Please upload the email below from the applicant and the revised drainage plans that are attached to this email onto Ocella for BE/21/20/DOC – Salt Box.

Engineers comments in respect to surface water drainage;

APPLICATION NO: BE/21/20/DOC

Site Address: Land At Salt Box West Of Shripney Road Bognor Regis PO22 9NW

HYDROCK PROJECT NO. C-13319-C		SCALE @ A1 1:250	
STATUS DESCRIPTION TENDER			STATUS D2
DRAWING NO. (PROJECT CODE-ORIGINATOR-ZONE-LEVEL-TYPE-ROLE-NUMBER) SAL-HYD-PH2-ZZ-DR-C-7011			REVISION P03

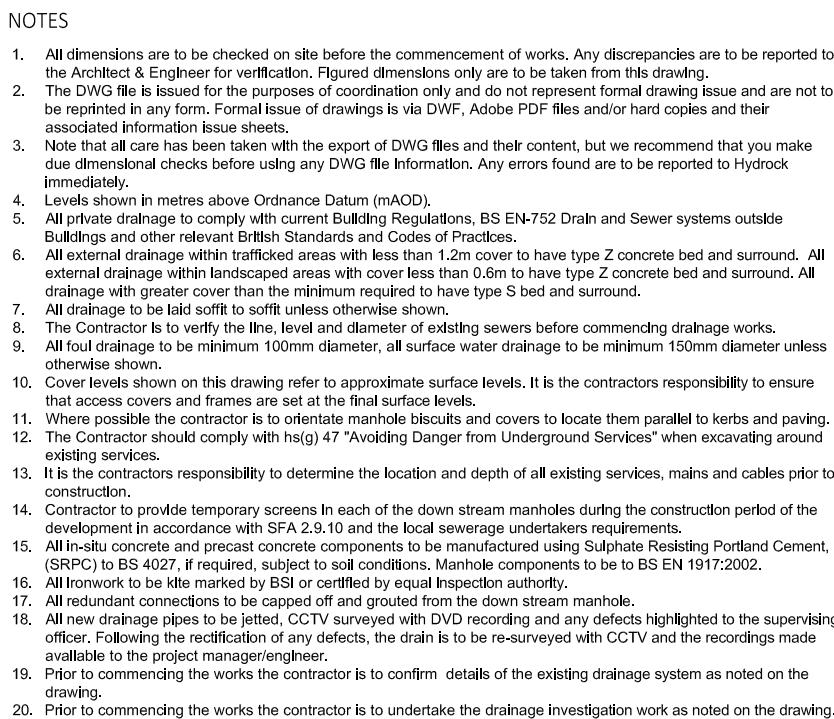
7. Manhole SW-900 invert level is different on plans 7011 and 7022. Noted.

9. Drawings 7011 and 7012 – Remove any trees etc being shown within proximity of the proposed pipeline.

PH1-7022 IL revised to suit PH2-7011. ok

Noted. Trees removed. ok

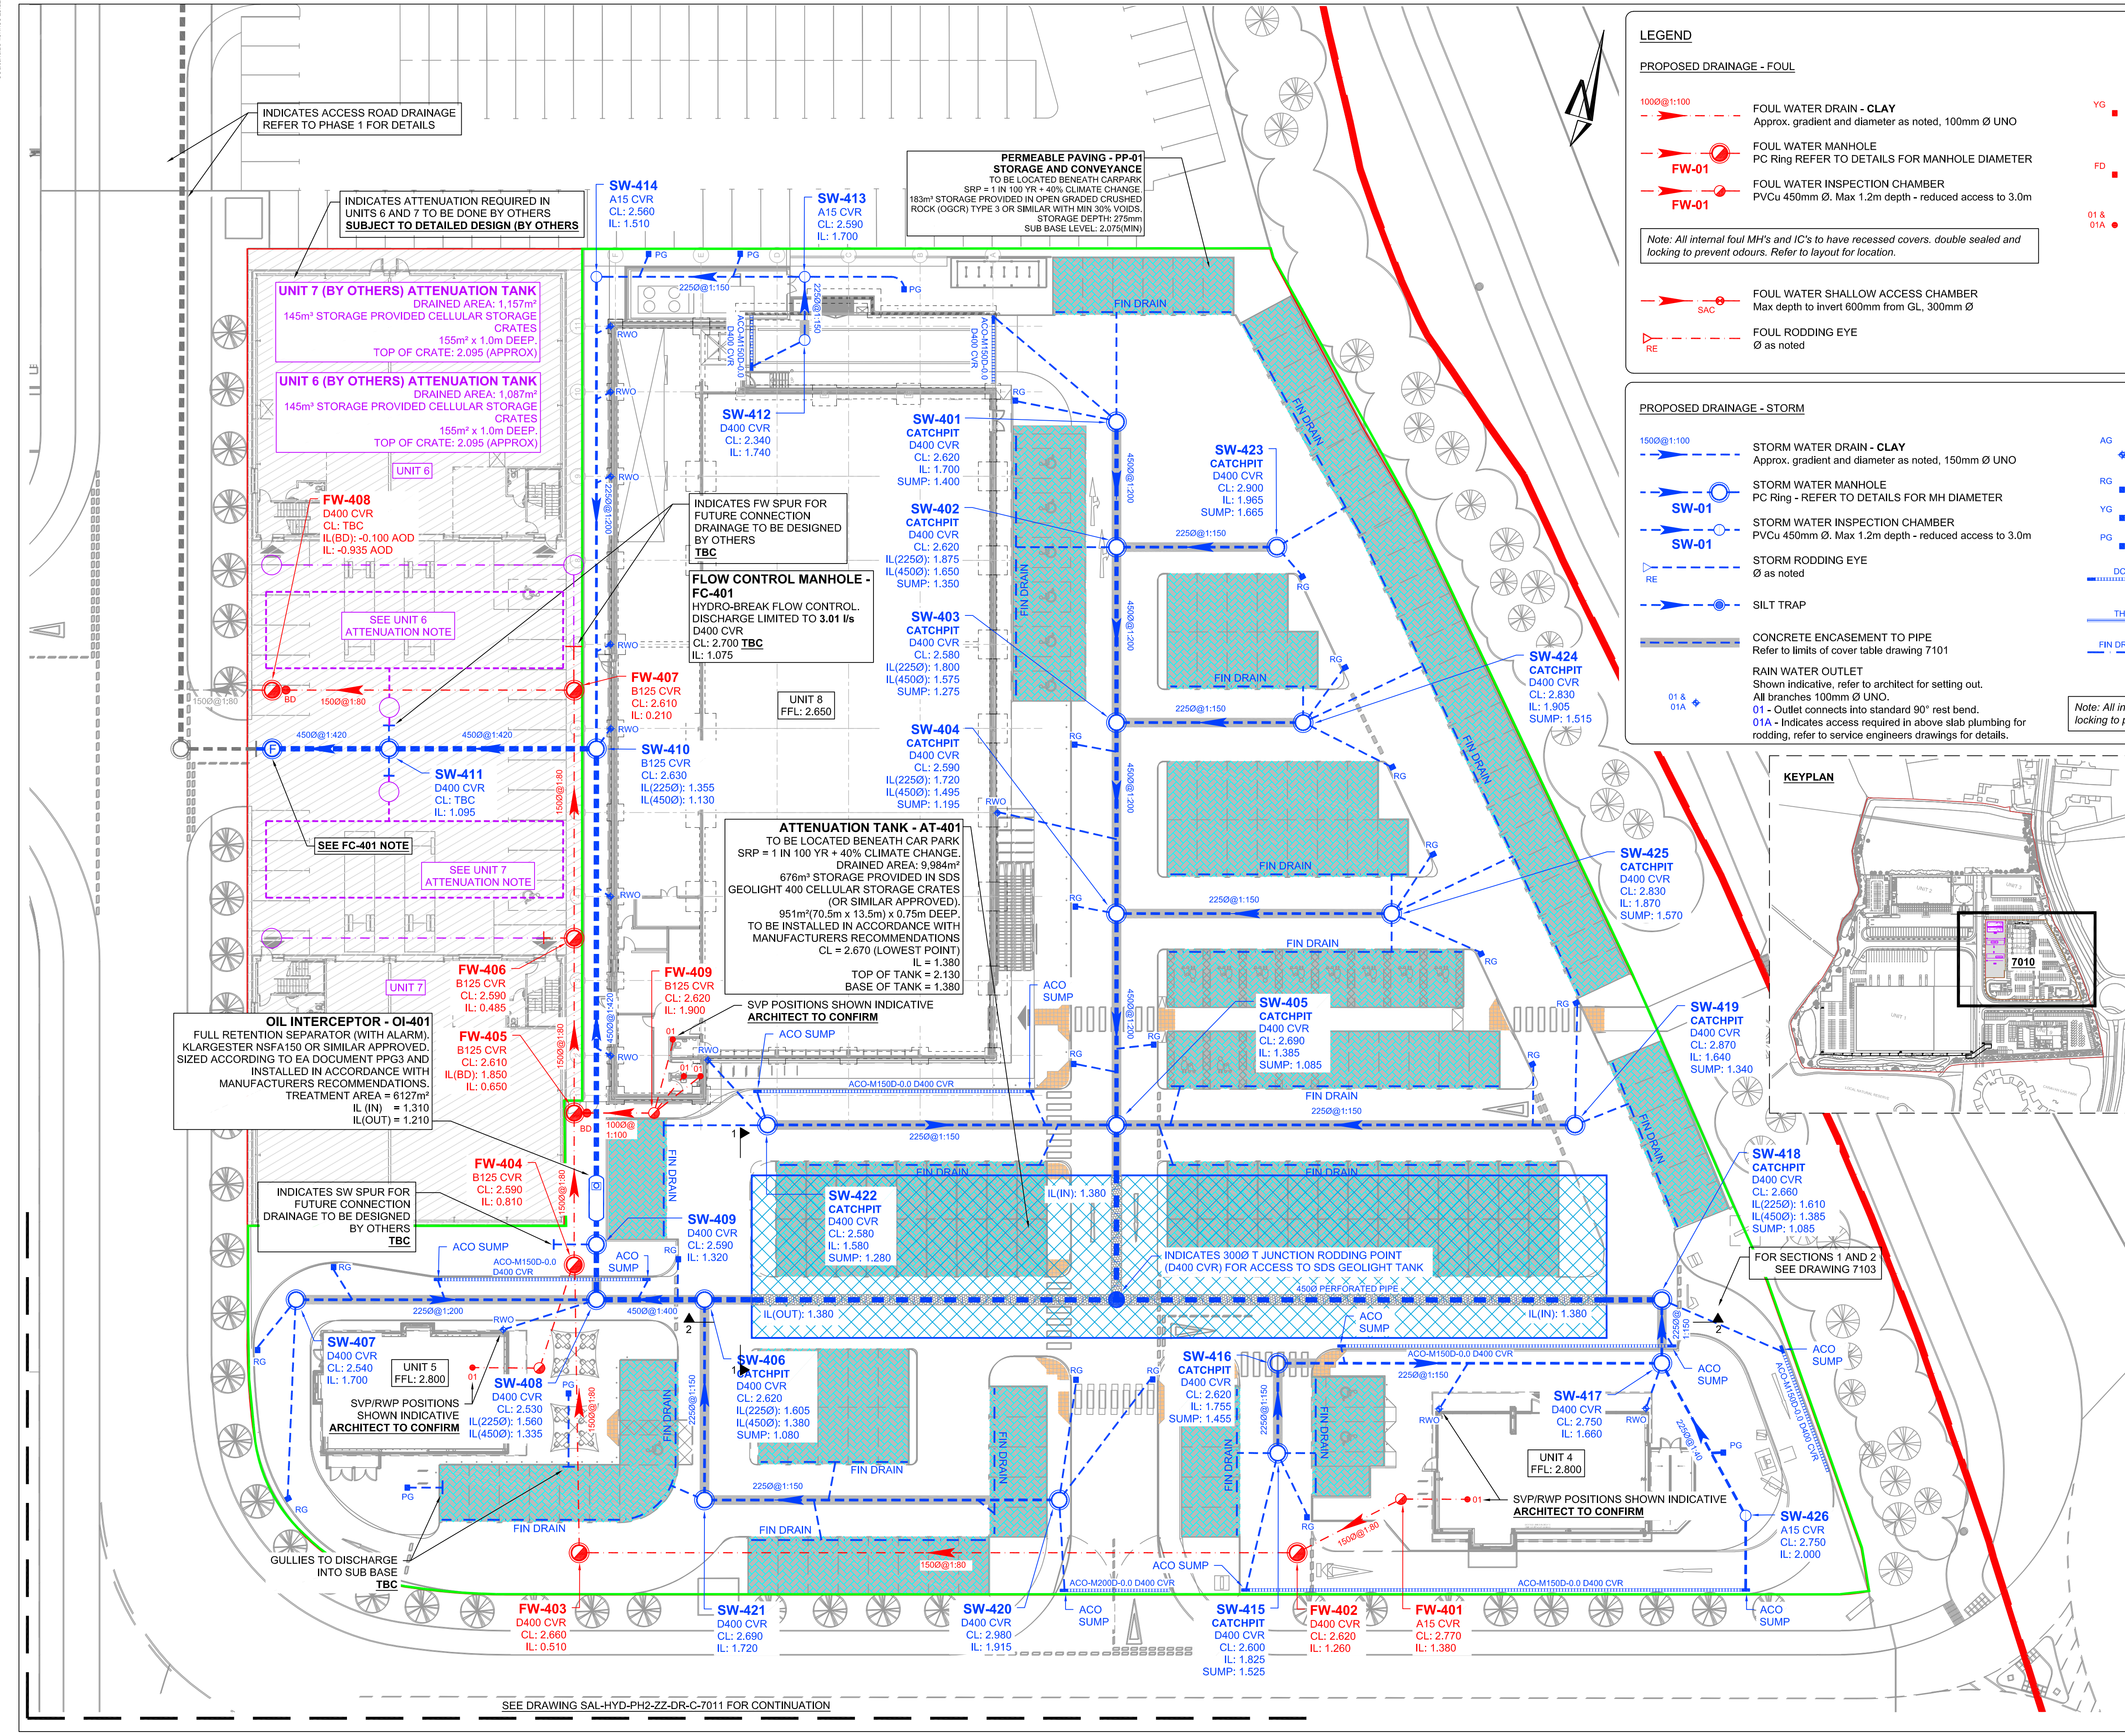
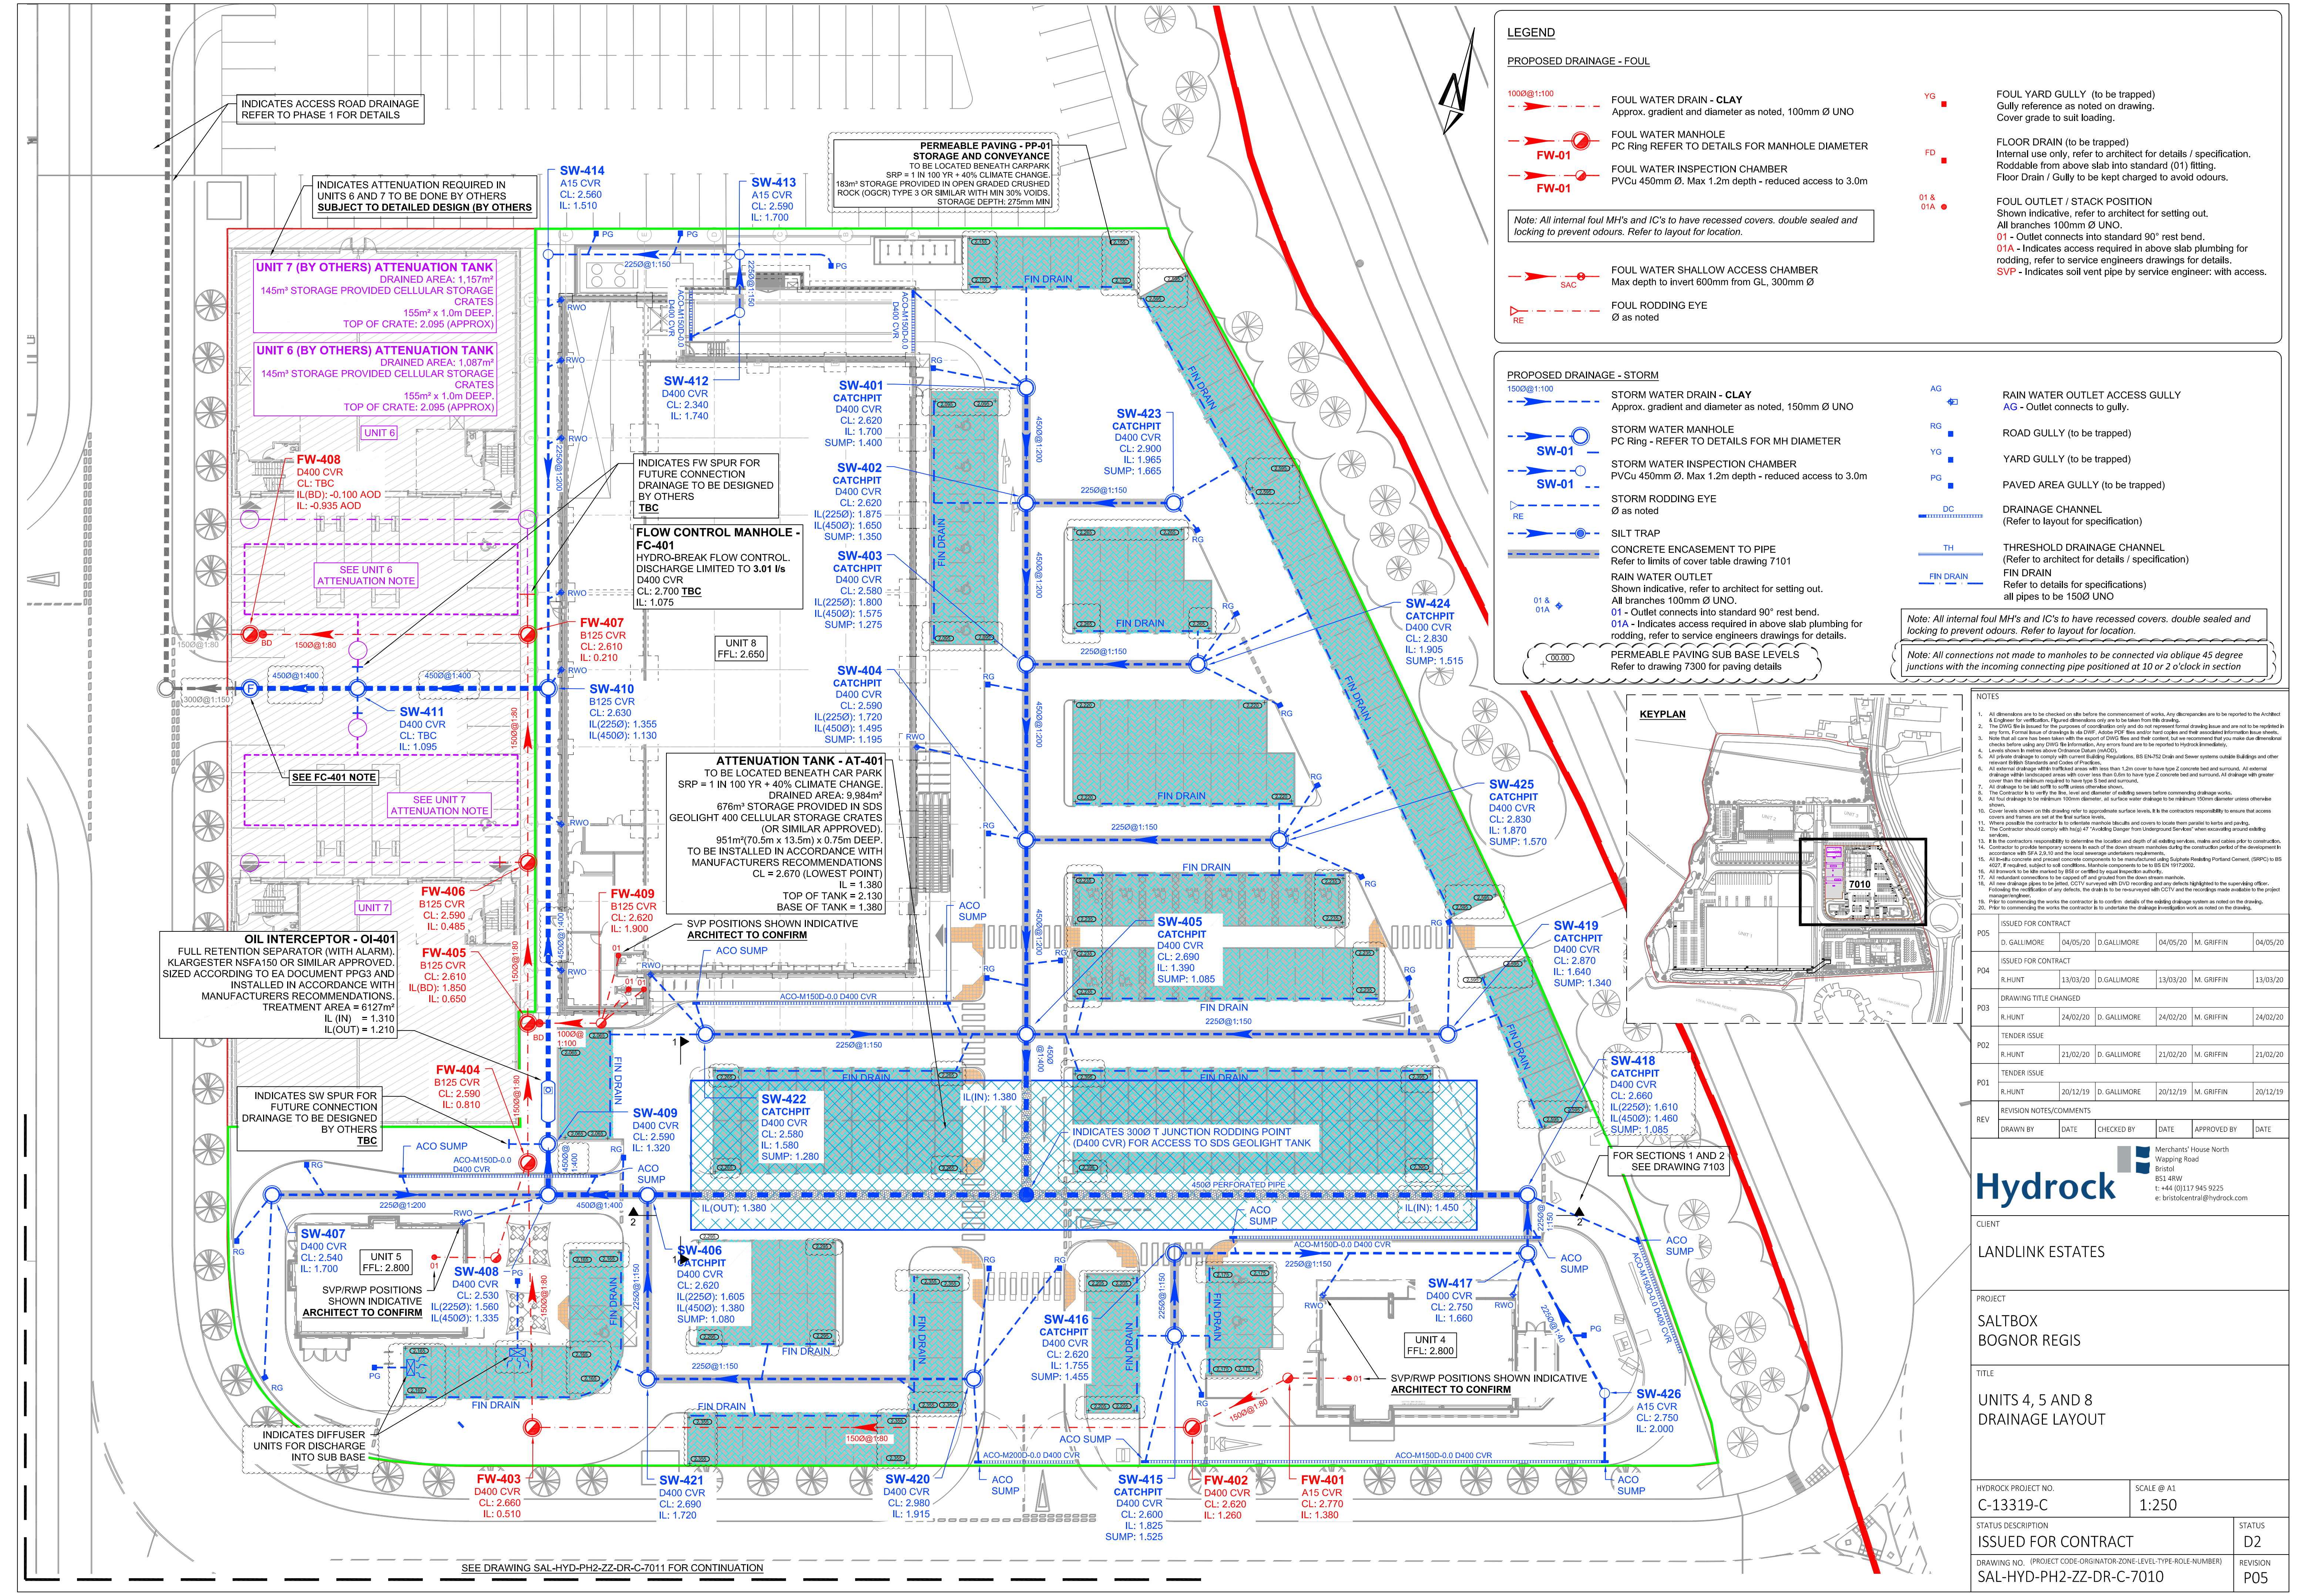
10. Improve gradient FC-401 to 01-401 to min 1 in 400.

14. Drawing 7010 – specify sub base levels for ALL permeable paving areas. On drawing 7300 – add note to refer to sub base levels on drawing 7010.

15. Drawing 7010 - SW-405 to tank – specify pipe diameter and a reasonable gradient.

Pipe gradient updated. ok

Sub base levels added To 7010 and note added to 7300. ok

Gradient added ok

DETAIL PG: PAVED GULLY
SCALE 1:10

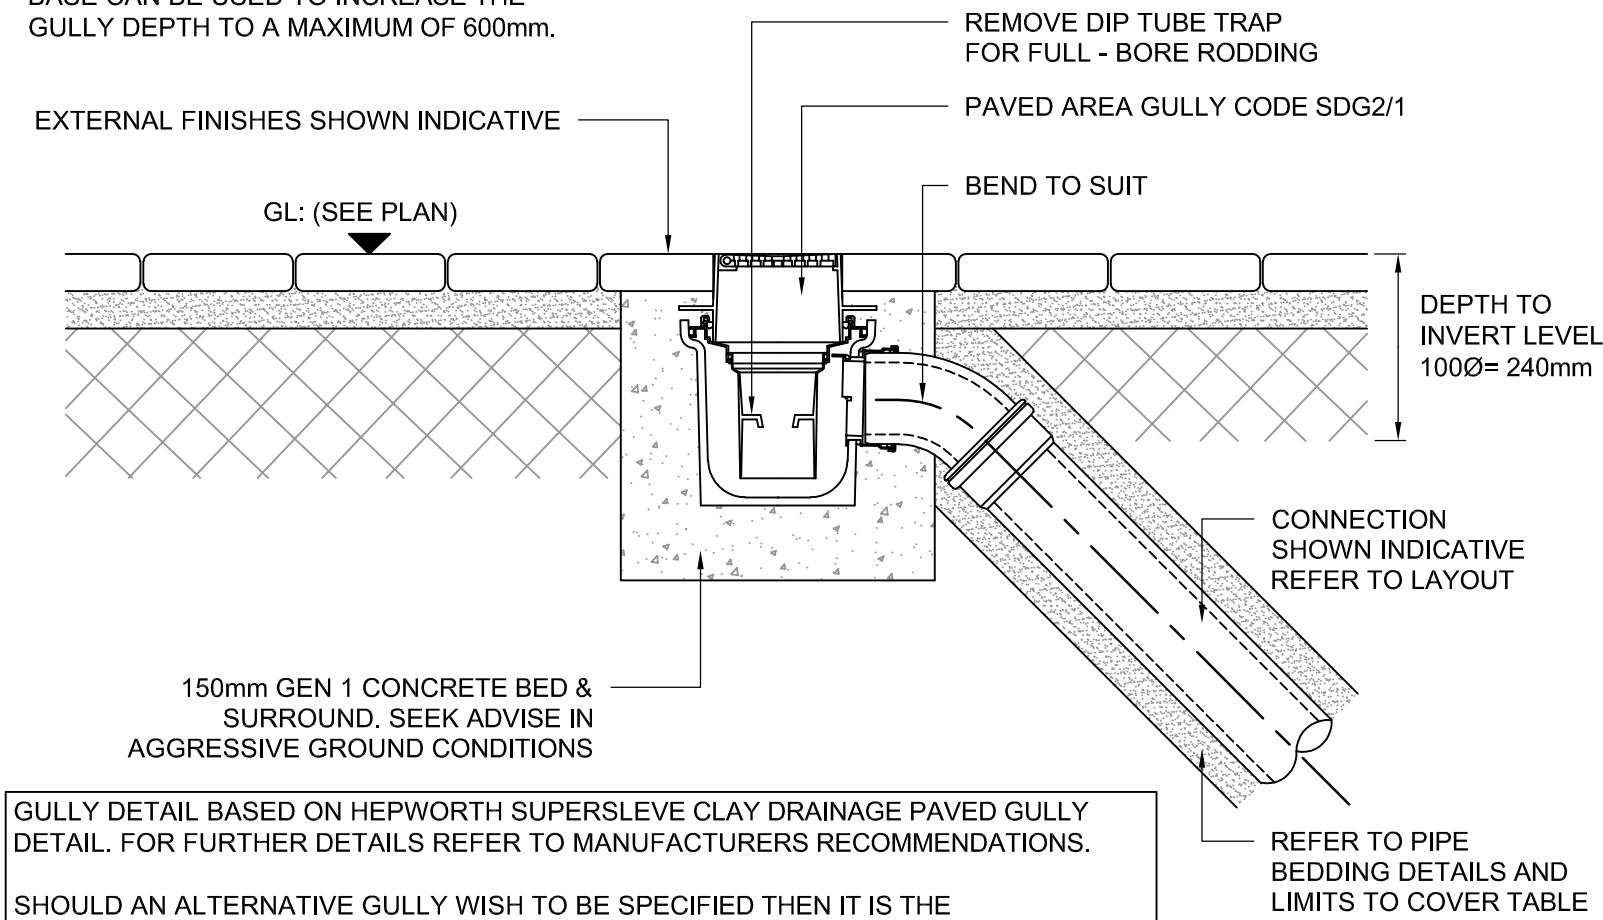
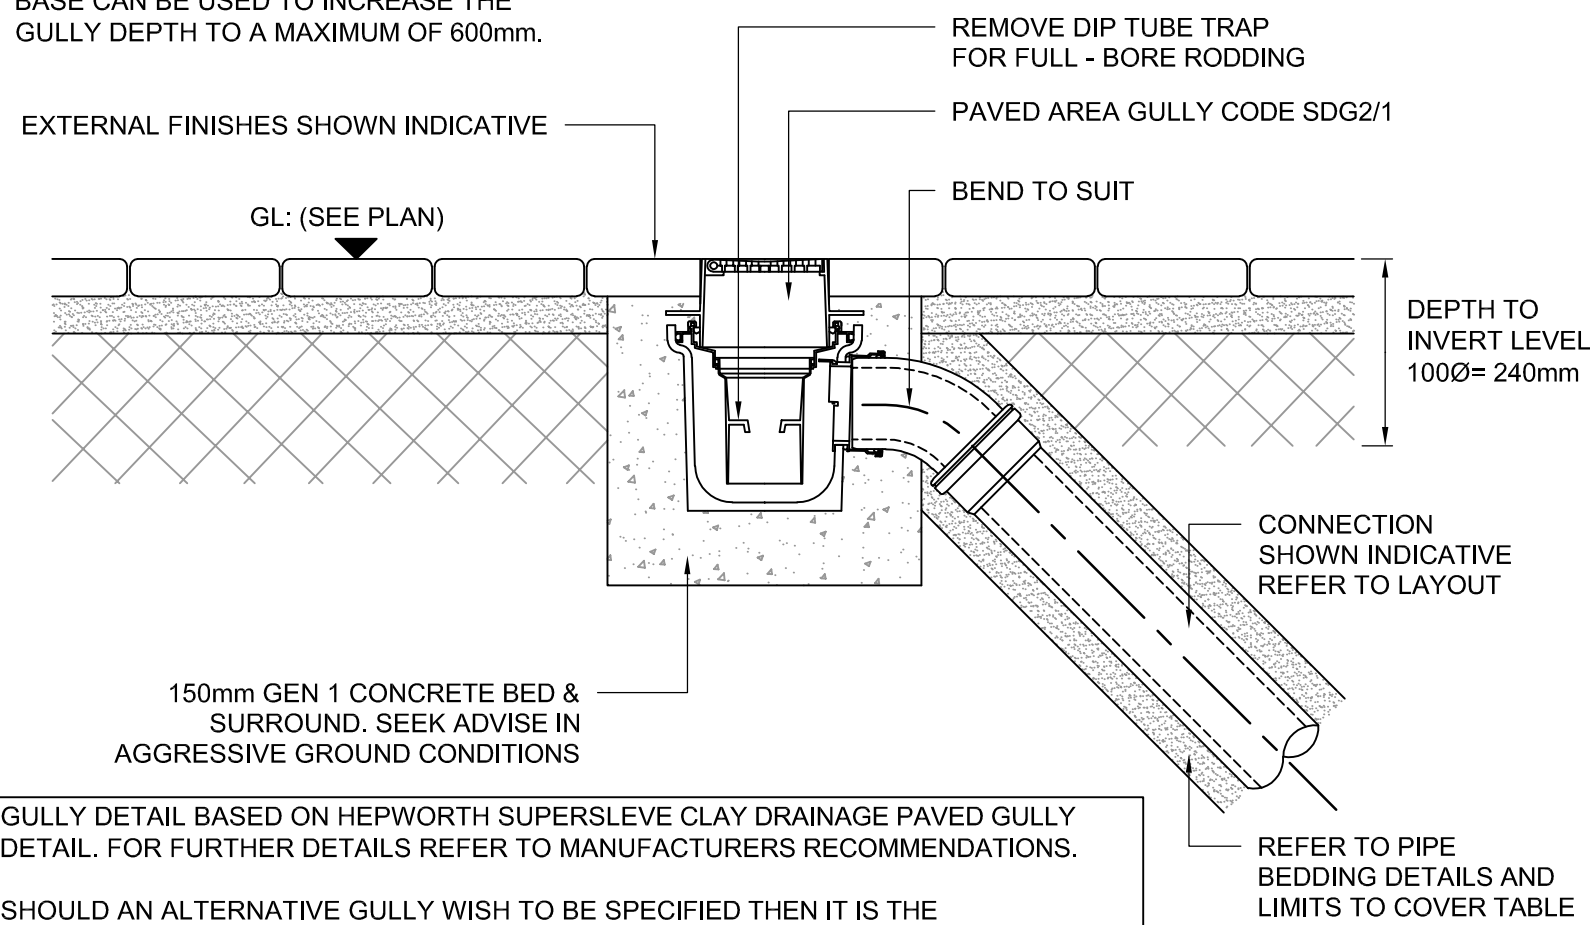
12. Provide PG paved area gully construction detail (to incorporate silt trap).

PG detail added ok
